Application No: AL/54/22/HH
Site Address: Dove Cottage Nyton Road Westergate PO20 3UN
Description of works: Creation of first floor with 2 x rear dormers with juliet balconies and 3 x front rooflights, erection of single storey rear extension, summer house to rear, installation of car port to front and alterations to fenestration.

Thank you for your internet representation made on 15th June 2022 which has been recorded as no objection with the comments as follows:

For MR & MRS BARDGETT		Title PROPOSED SOUTH & WEST ELEVATIONS		Office Tel: 01243 933732	
Project PROPOSED EXTENSION AT DOVE COTTAGE, NYTON ROAD PO20 3UN		Date MARCH 22	Drawn JB	Scale 1:100 @ A3	Checked -
		Job Number PL 569.22	Drawing Number -06	Revision A	Web: www.jb-architecturedesign.com

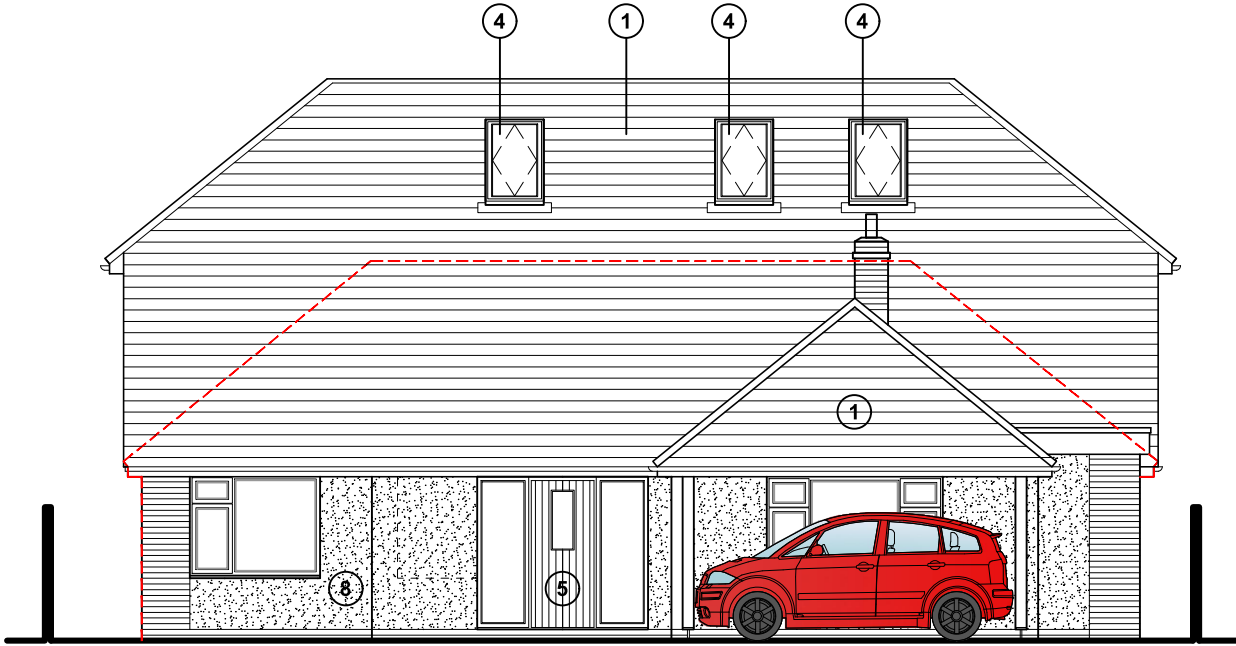
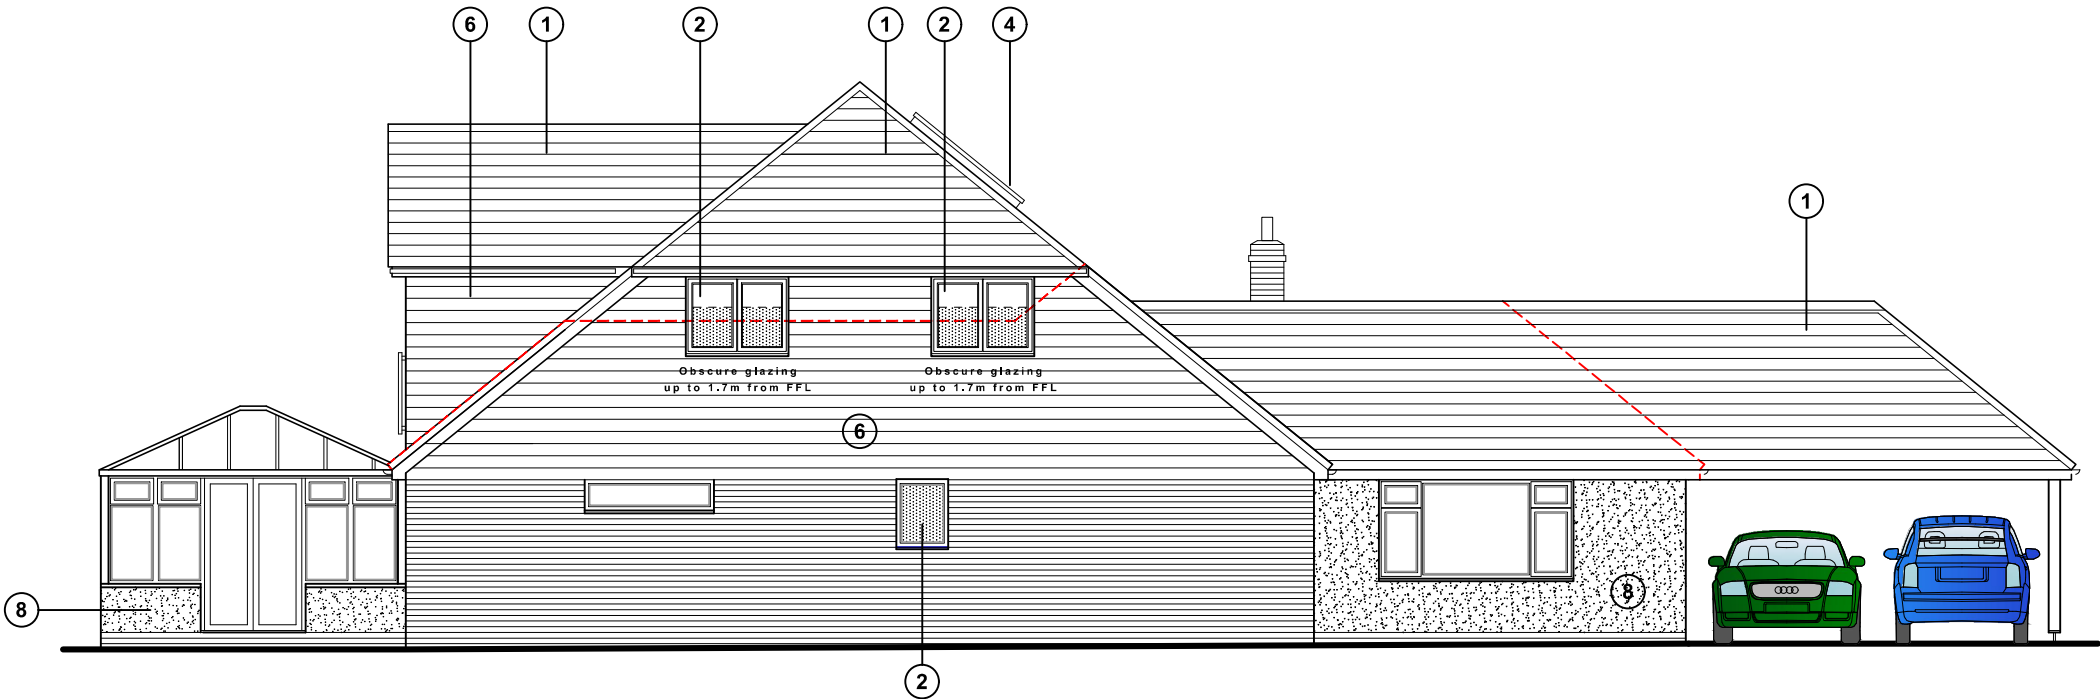
The Parish Council has no objection to this application although we would like it noted that the roof lights may contravene EH10 Dark Skies Policy in our ANP.
